From: Sue Howell
Sent: 15 August 2019 16:41
To: Planning.Responses <Planning.Responses@arun.gov.uk>
Cc: Michael Eastham <Michael.Eastham@arun.gov.uk>
Subject: RE: Planning Consultation on: EG/22/19/OUT

Comments from Greenspace

APPLICATION **EG/22/19/OUT**

Description of Works: Outline application with some matters reserved for the erection of 28 No. dwellings, access, landscaping & associated works (resubmission following EG/42/18/OUT).

CONCEPT MASTERPLAN

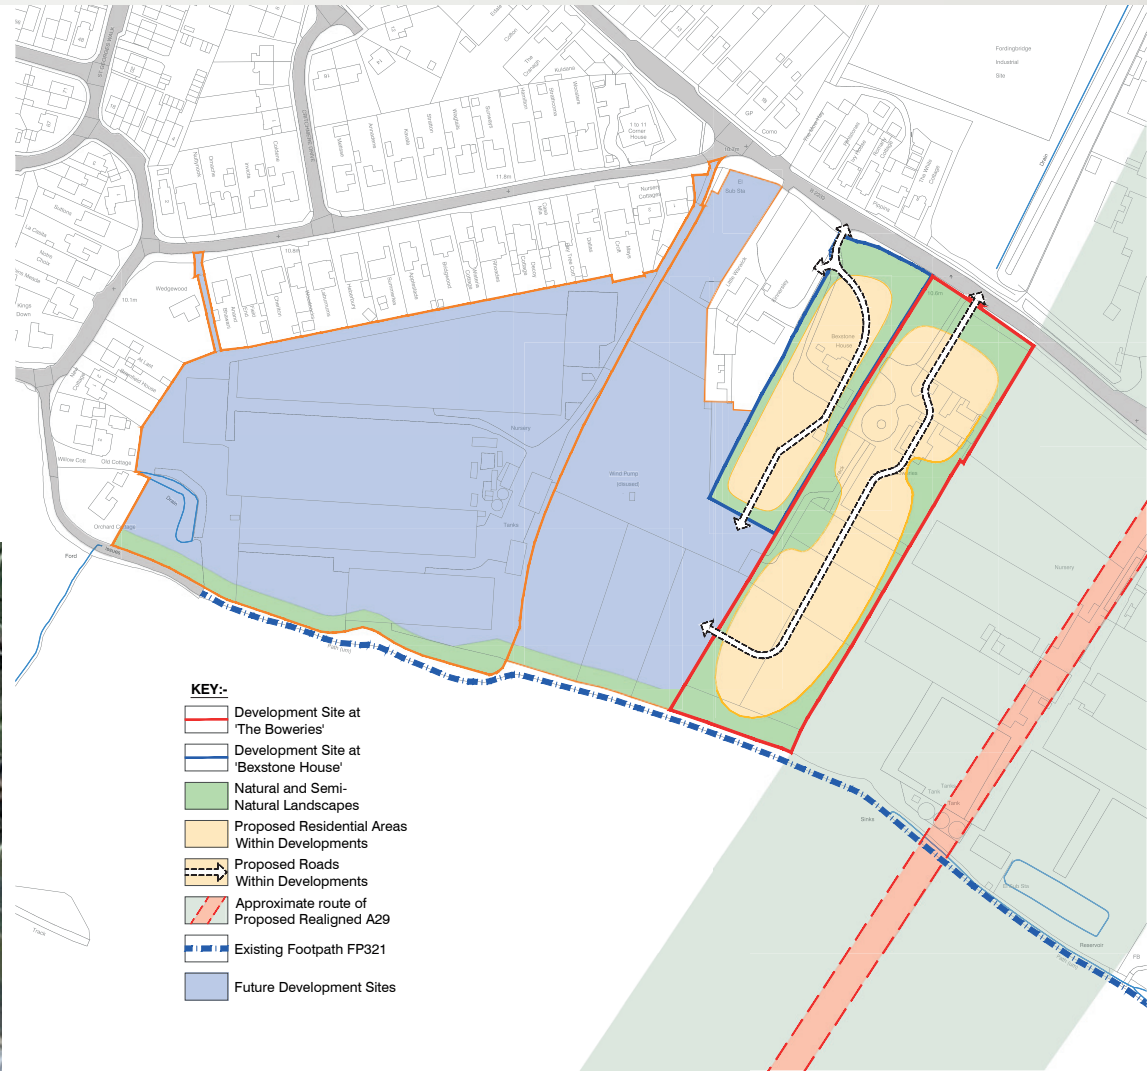
It is encouraging to see that the red line development has been shown in conjunction with the masterplan for the wider area. It is not clear however how the existing trees within the site are to be accommodated and also how the connectivity with the adjacent site will be demonstrated. There would appear to be noted existing tree presence on this site with some detailed for removal in order that the development could proceed. Details of this tree loss would need to be shown along with the mitigation planting to be introduced with the proposals.
